**Re: Coles Metal
3435 Vassar Dr NE
Request Permanent C.O. - Accepted
Engineer's Stamp Dated 6-23-16 (G16D150)
Certification dated: 1-6-17**

Based upon the information provided in your submittal received 12-19-2016, the above referenced plan cannot be approved for PERM CO until the following comments are addressed:

**RE: Coles Metal Building/Shed addition
Grading and Drainage Plan
Engineer's Stamp Date 6-23-16 (File: G16D150)**

Re: Bogan Brothers Painting
3435 Vassar Dr., NE
Traffic Circulation Layout
Engineer's/Architect's Stamp **6-6-16** (G16-D150)

**TCL**

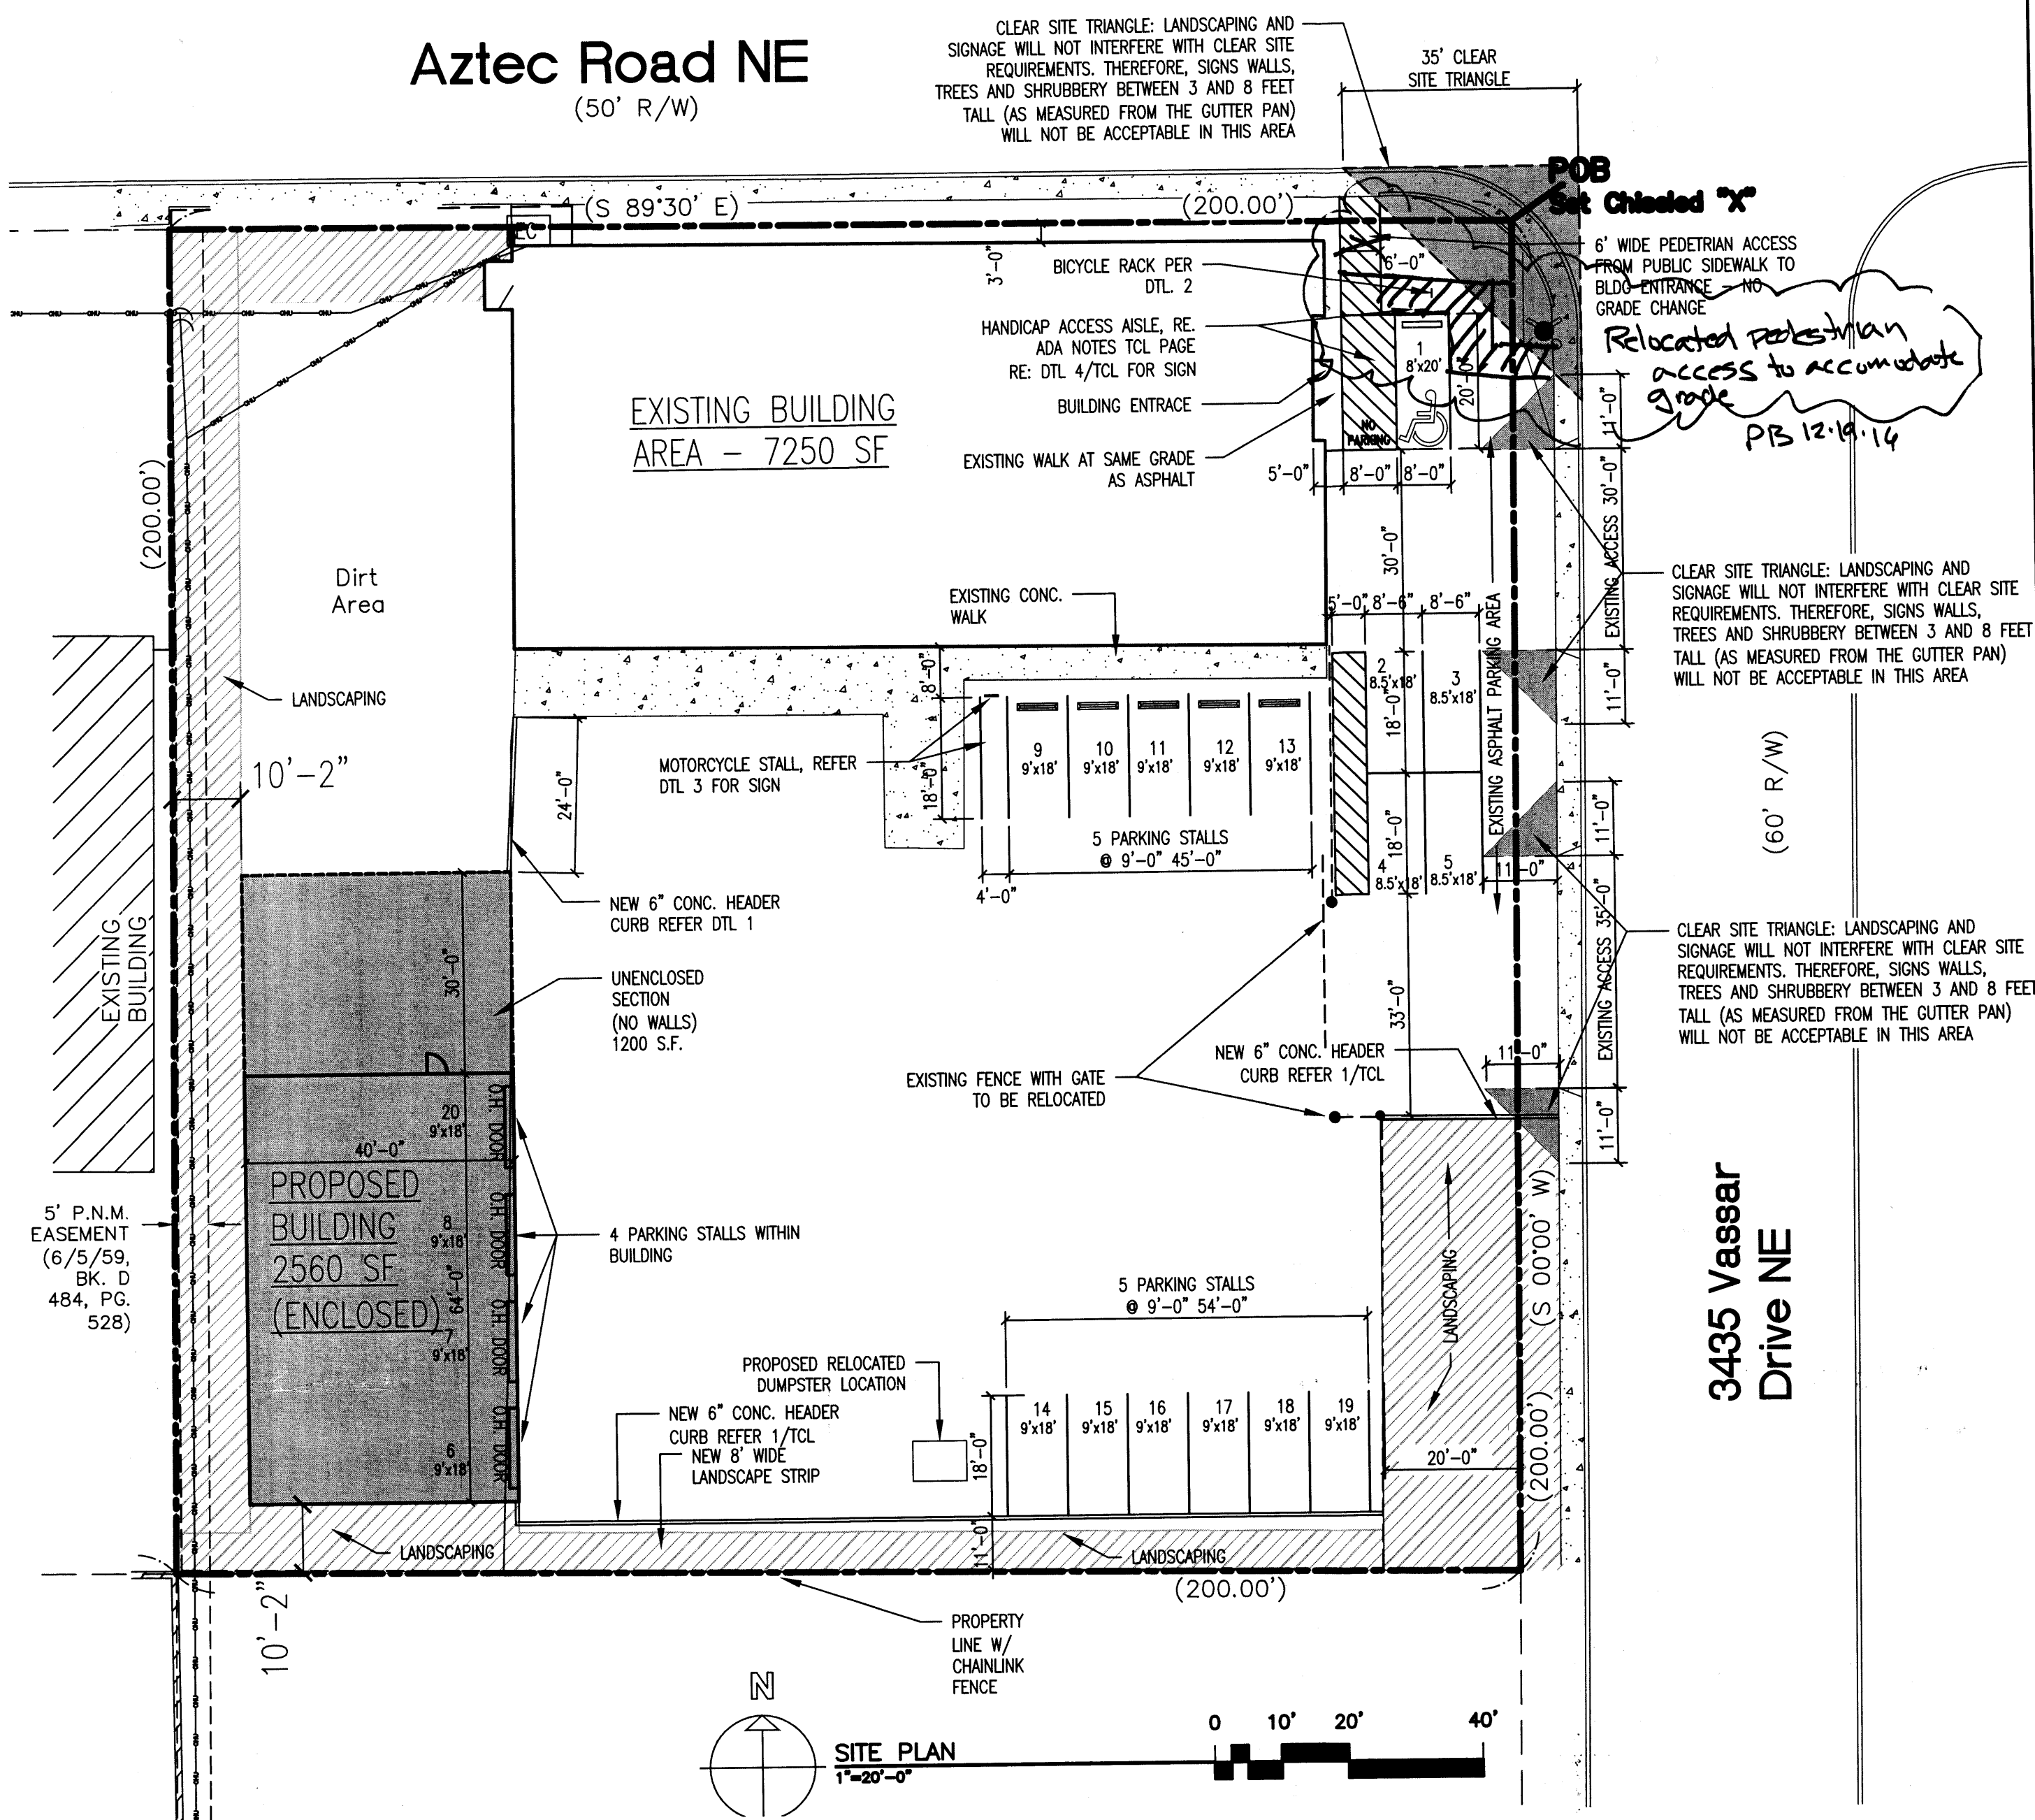
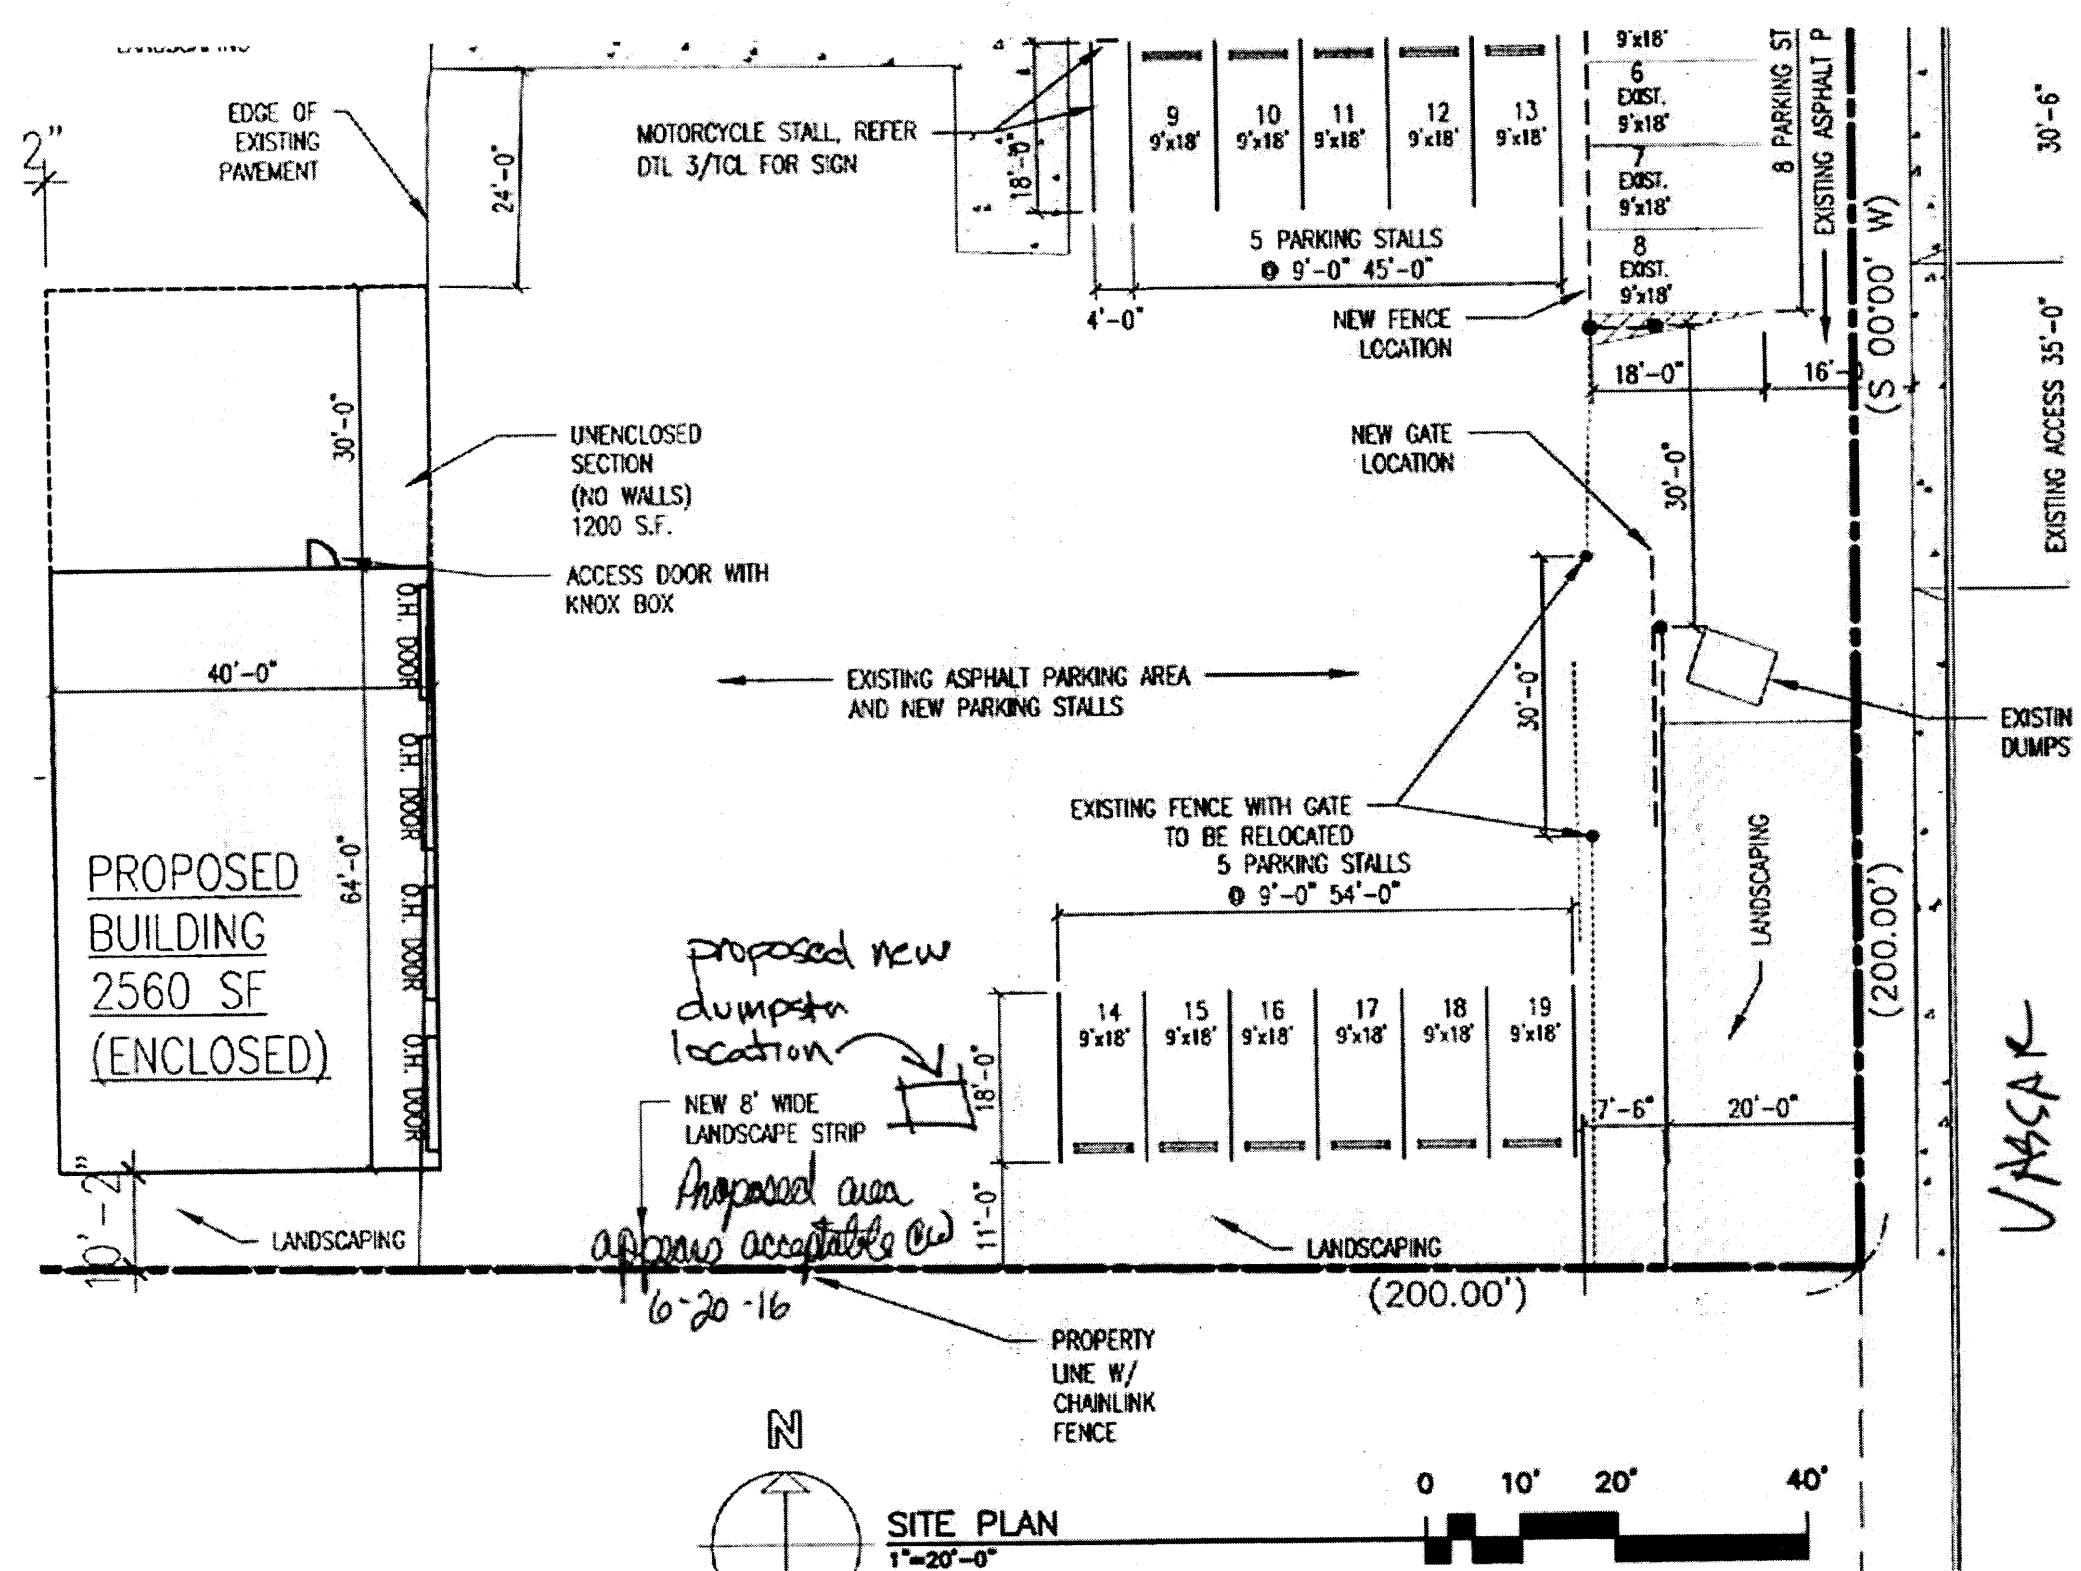
1. Please detail and dimension all buildings, parking spaces and ADA ramps and anything that influences the parking and circulation on the site. Previous digital maps show parking spaces on the north east corner of the parcel. Please detail the existing ADA ramps on the existing curb cuts.

2. Parking spaces are required to be a minimum of 8.5 ft. by 20 ft. In review of the submitted plans, the parking spaces on the east side of the existing building are not adequate in length and do not provide a minimum of 24 ft. drive pad between the parking spaces and the ROW for adequate backing up of vehicles. It is preferable that vehicles do not back up onto streets when exiting.

3. Per DPM, a 6 ft. wide ADA accessible pedestrian pathway is required from the HC parking stall access aisles to the building entrances. Please clearly show this pathway and provide details. Please dimension the access isle.

4. ADA parking spaces require a minimum of 8.5 ft. X 20 ft. per parking space. Please revise site plan to accommodate adequate ADA parking spaces and access isle. In review of the submitted site plan, the parking spaces are 16 ft. in length. Evaluate moving HC spaces to south east corner of the existing building and providing a 6 ft. pedestrian access to the building entrance. The parking spaces may also be angled, if appropriate for the design.

5. Service vehicle and/or refuse vehicle maneuvering must be contained on-site; provide a copy of refuse approval.
6. All broken or cracked sidewalk and ADA ramps must be replaced with sidewalk and curb & gutter. A build note must be provided referring to the appropriate City Standard drawing.

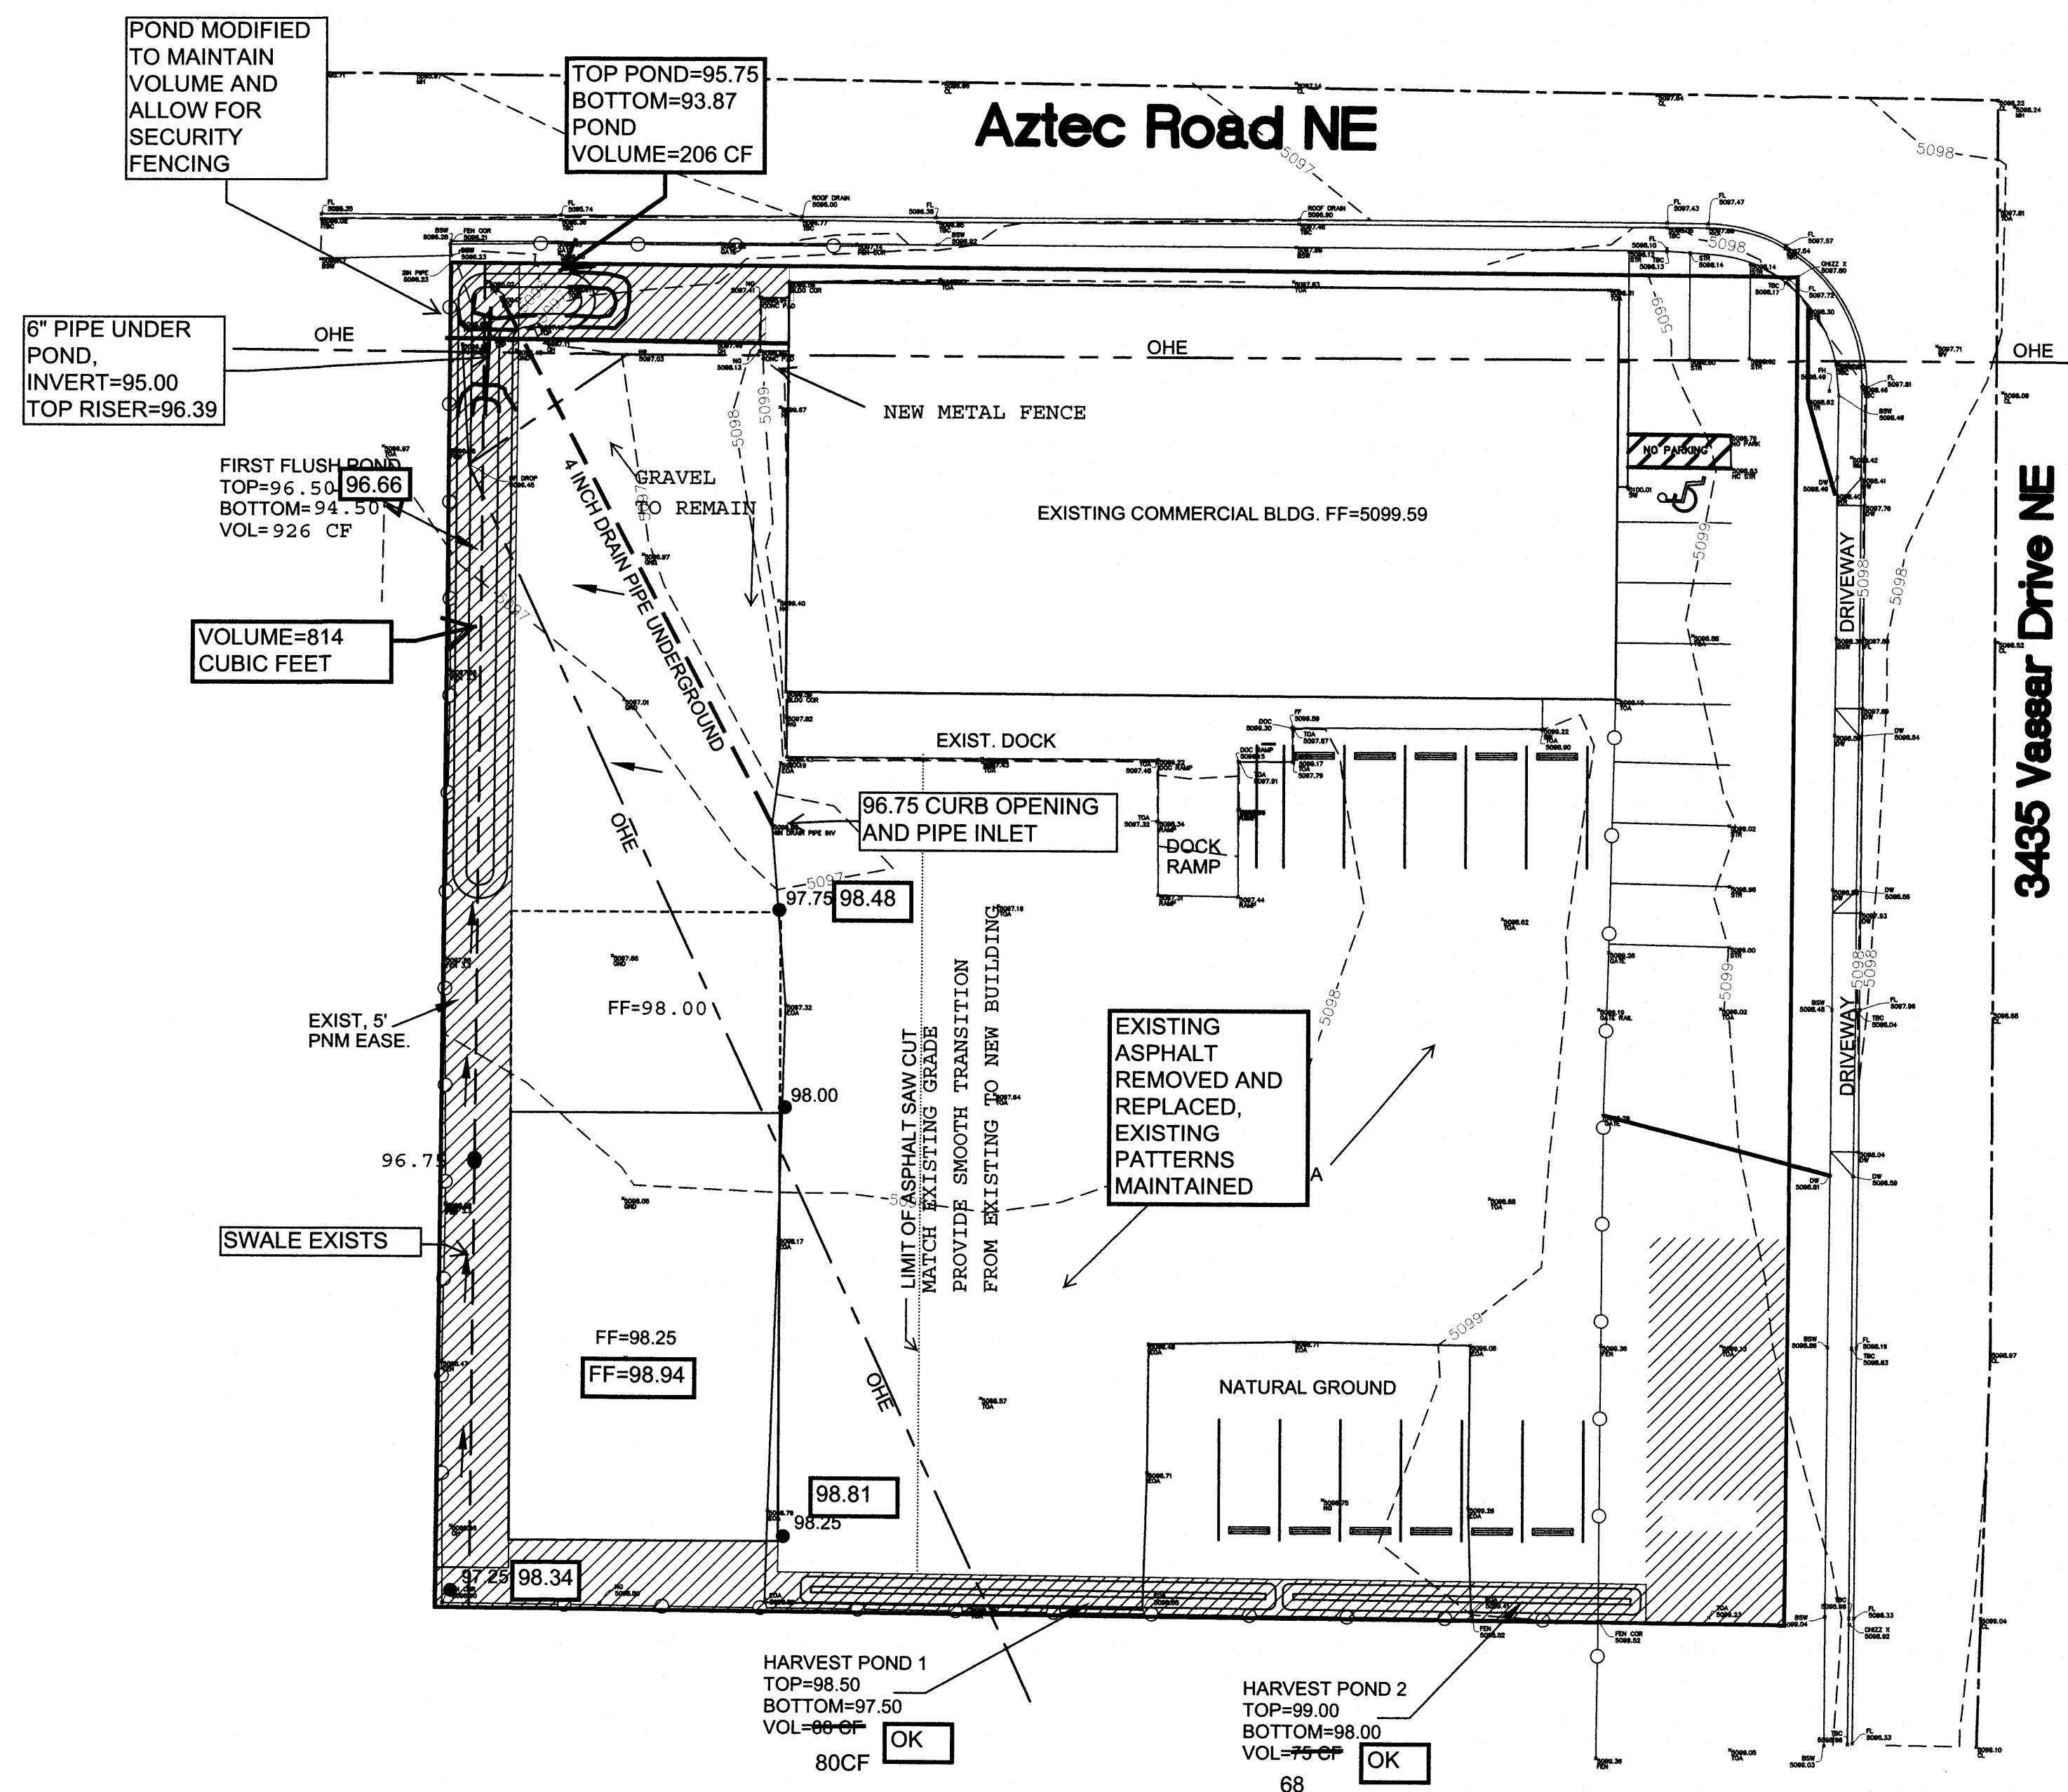
- There appears to be an outfall on the property. Pipe needs grate on top. As-built does not indicate where it flows. See attached pic.
- End of 4" pipe at NW corner in pond is covered. Unable to see.
